Application Ref:	3/2021/0254	 Ribble Valley Borough Council www.ribblevalley.gov.uk
Date Inspected:	11/05/2021	
Officer:	AB	
DELEGATED ITEM FILE REPORT:		REFUSED

Development Description:	Proposed extension to create a one-bedroom holiday apartment and construction of two single storey one bedroom holiday let units with parking.
Site Address/Location:	Wellsprings Hotel Clitheroe Road Sabden BB7 9HN

Drawing Title
Proposed Site Plan

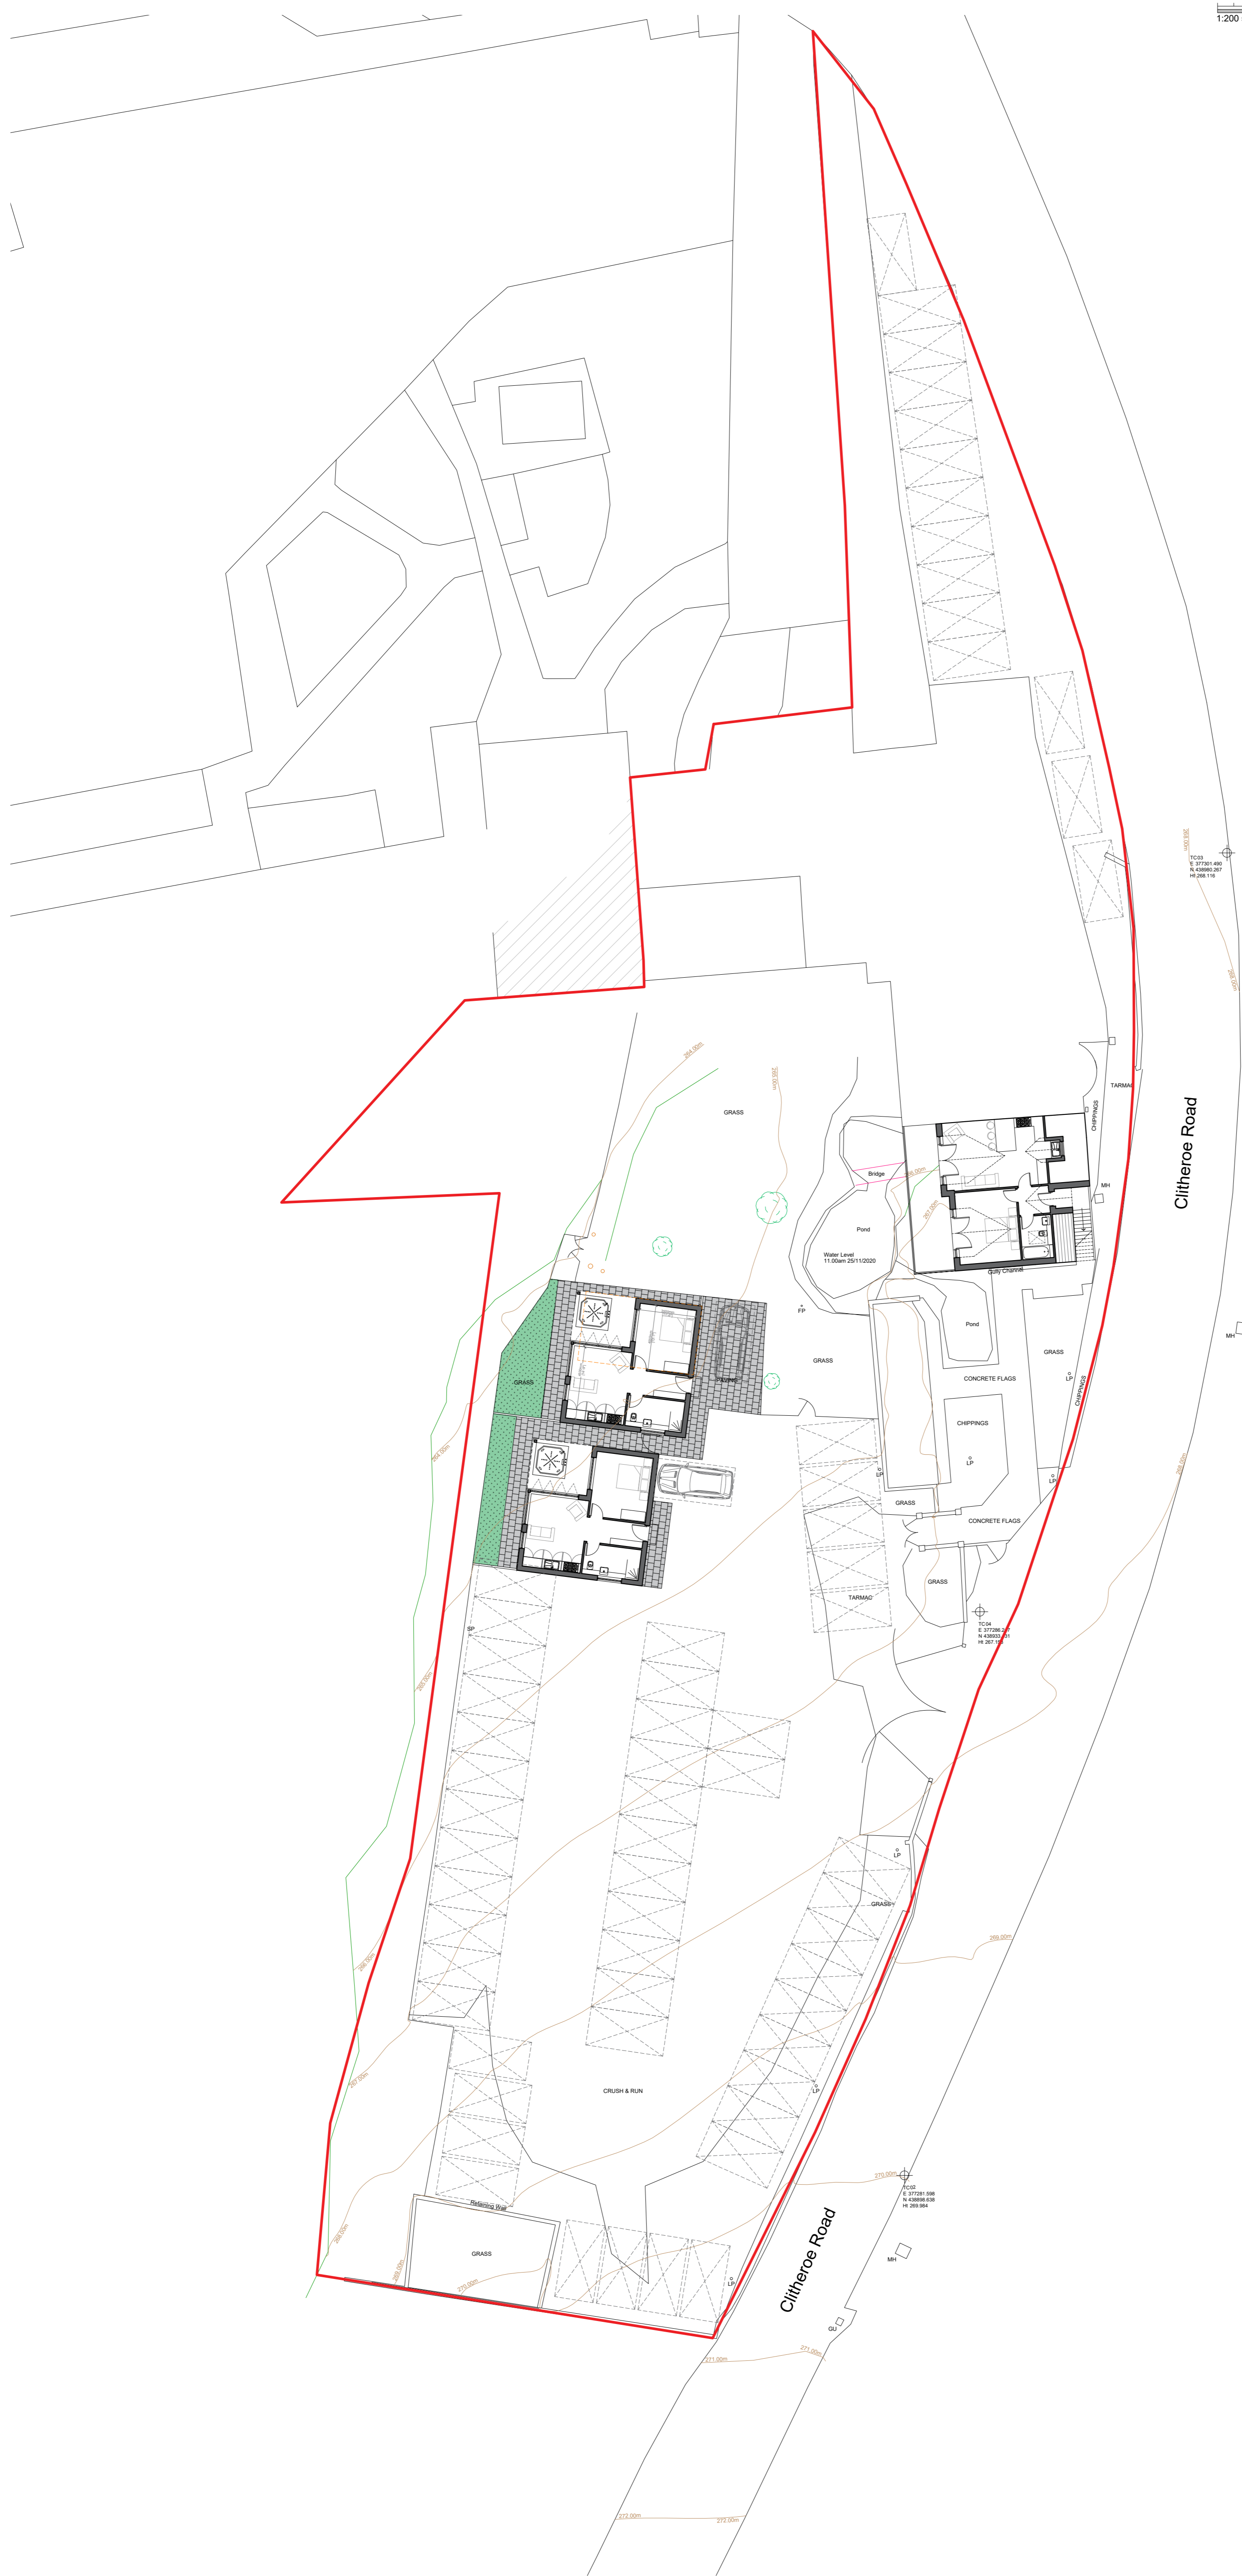
The County Highways Officer has raised no objection to the proposals despite an overall reduction in parking provision at the site. It is noted however that a number of parking spaces shown on the ‘proposed site’ plan are unusable, including spaces projecting onto the adjacent highway.

6218 - P03	REV
	-

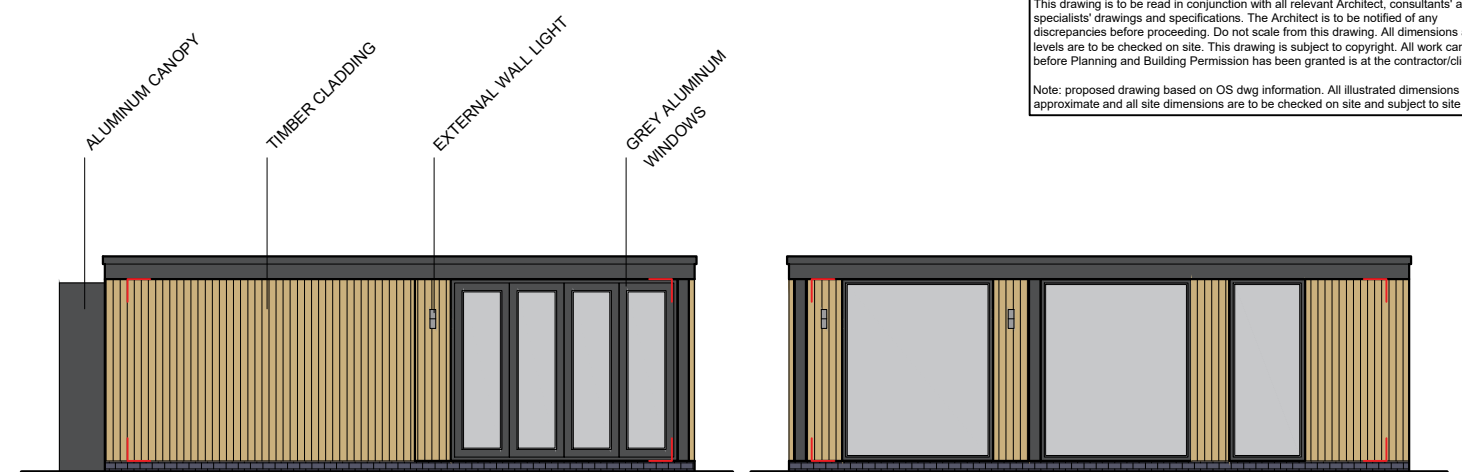
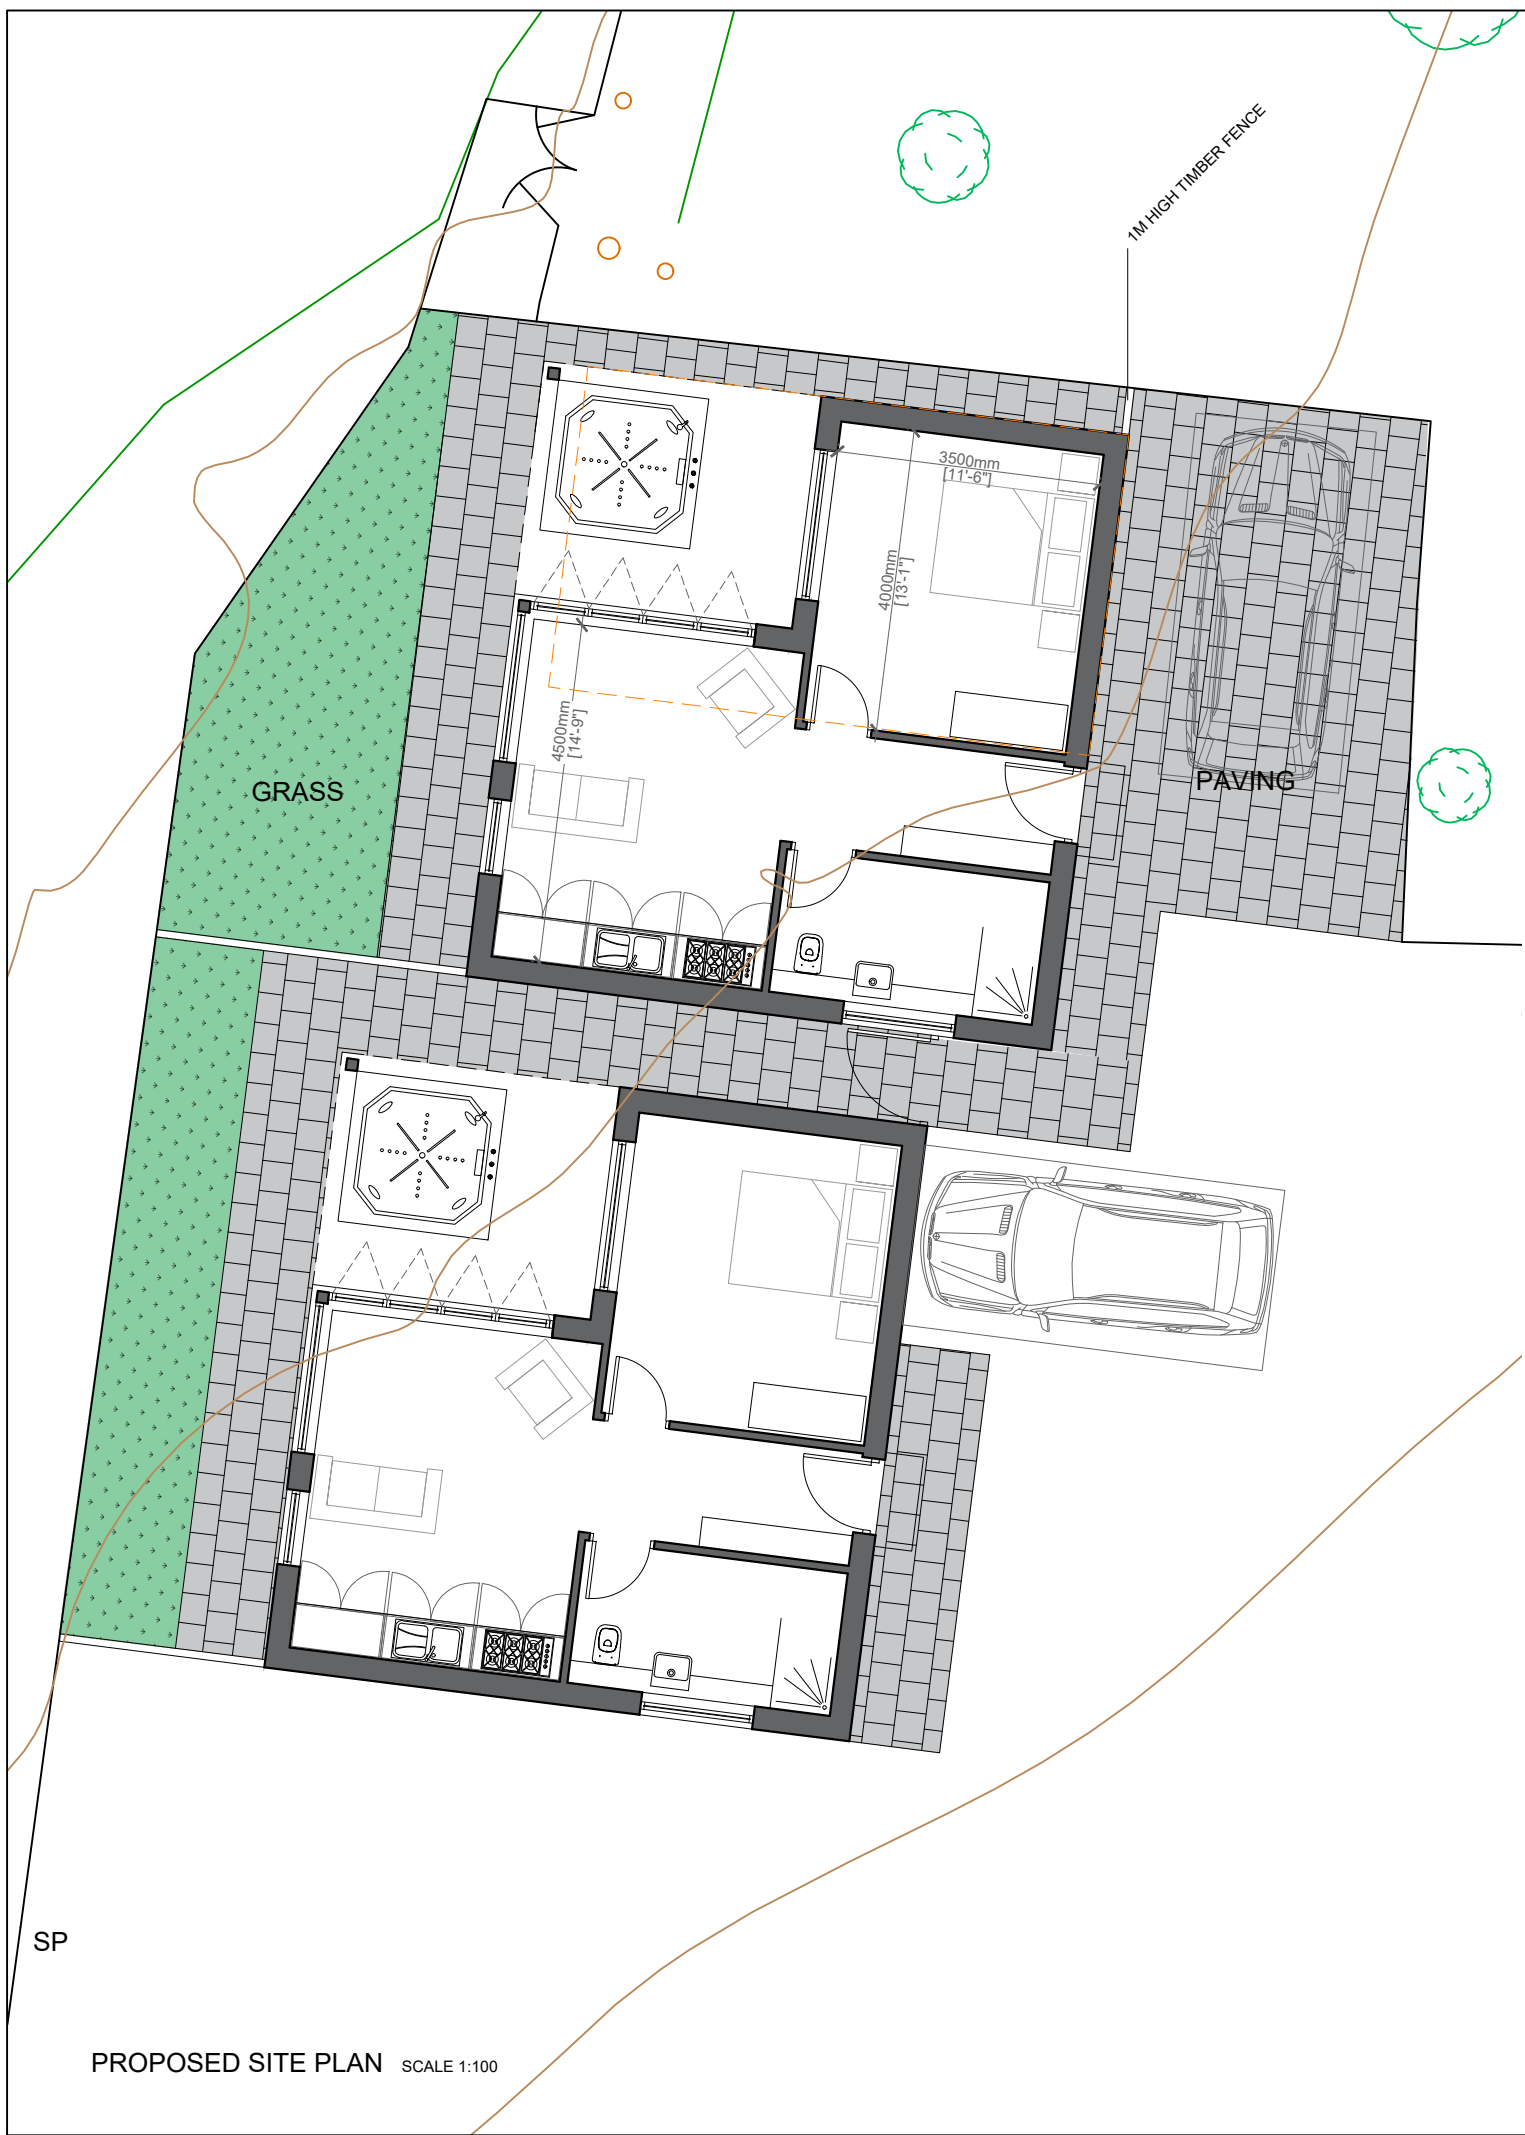
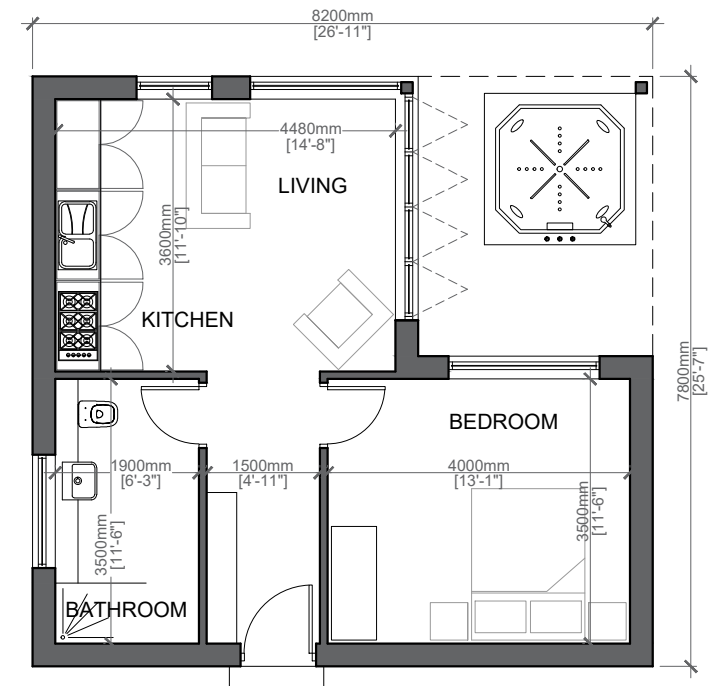
Regarding the detached holiday units, these would be afforded a high level of visibility and would fail to reflect local vernacular style in a highly sensitive landscape. The AONB Partnership has objected to the application with specific reference to the impact of the detached units and failure of the applicant to adequately consider the likely visual and landscape impacts.

**6218 - P02** REV -

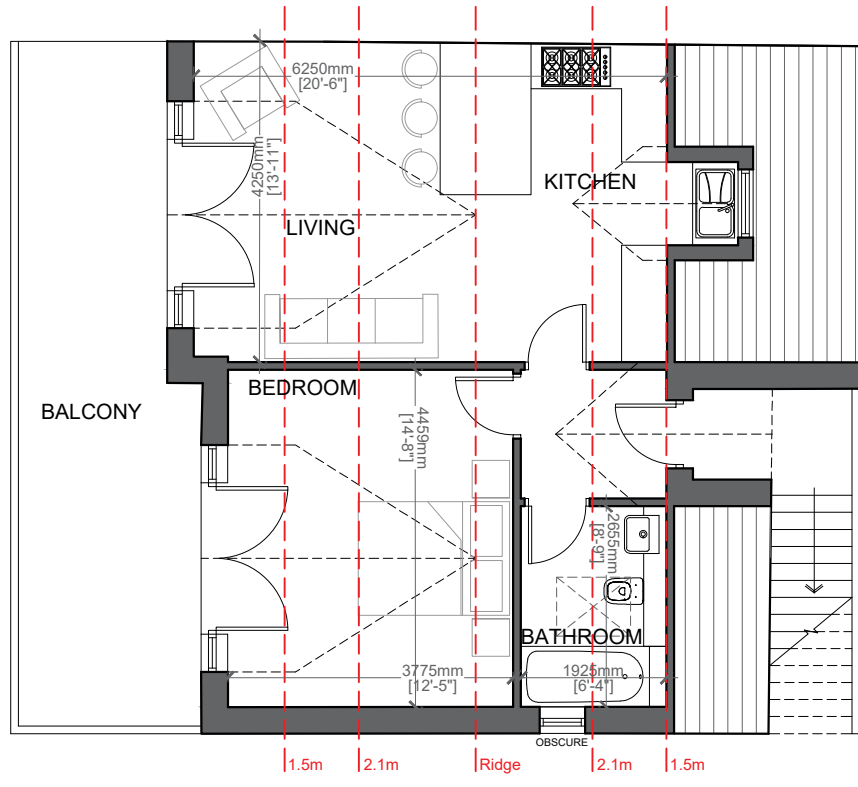
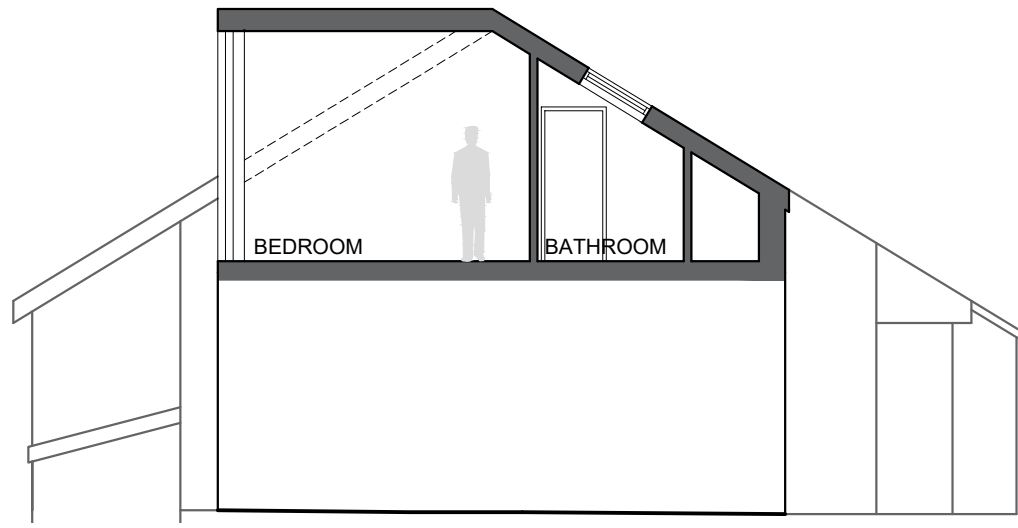
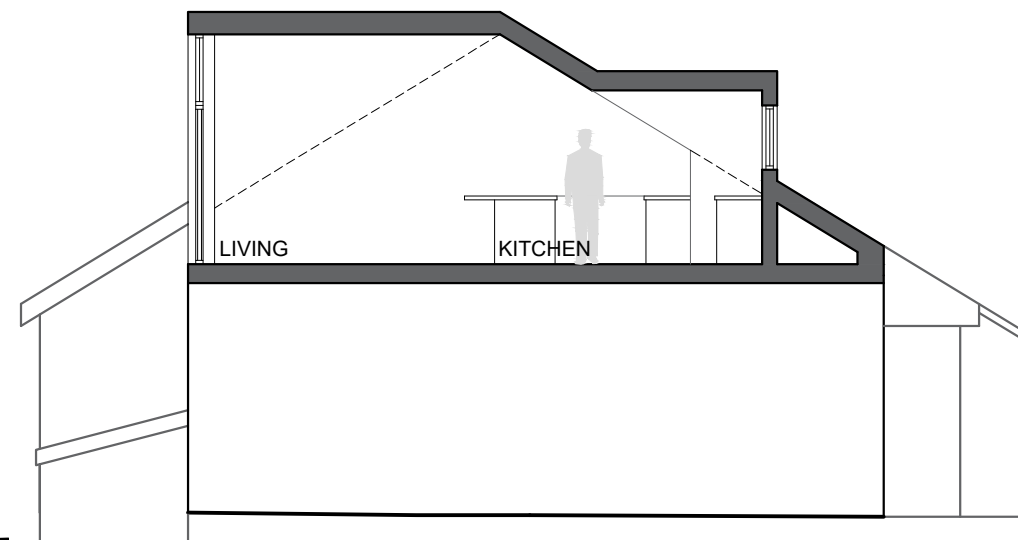
The proposed roof extension above the flat roof of the existing building does not raise any particular design concerns. However, the proposed pitched roof dormers and bulky, timber clad external stairway access at the roadside would be afforded high visibility from the highway and public footpaths. It is considered that these elements would result in a negative impact on the appearance of the building.

To the rear, the large-glazed dormers and balcony would also be highly visible and bulky additions to the rear roof slope, visible when approaching the building by car from both directions along Clitheroe Road. There would also be some long-distance views from the north-west.
